Addendum No. 1

RE: Contract # C204024

Wayne County (I-5935)

I-795 From US-70 To The Wilson County Line

**Wedging Detail For Resurfacing**

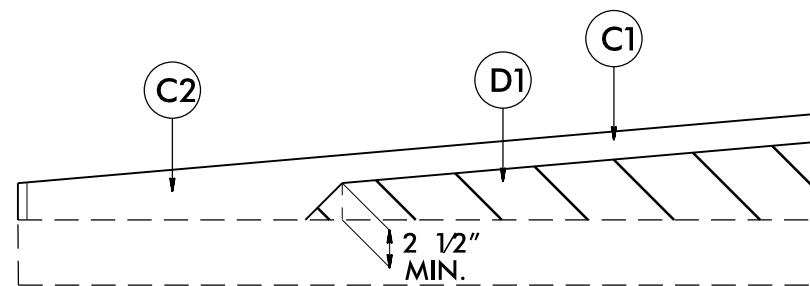
Sheet No.	Revisions
2	Added C2 Variable Depth Surface Course; Revised M1 milling to be variable depth 0" to 2" ; added a note concerning Ramp work and revised the Wedging Detail
3	Revised the column to show 0" to 2" Milling
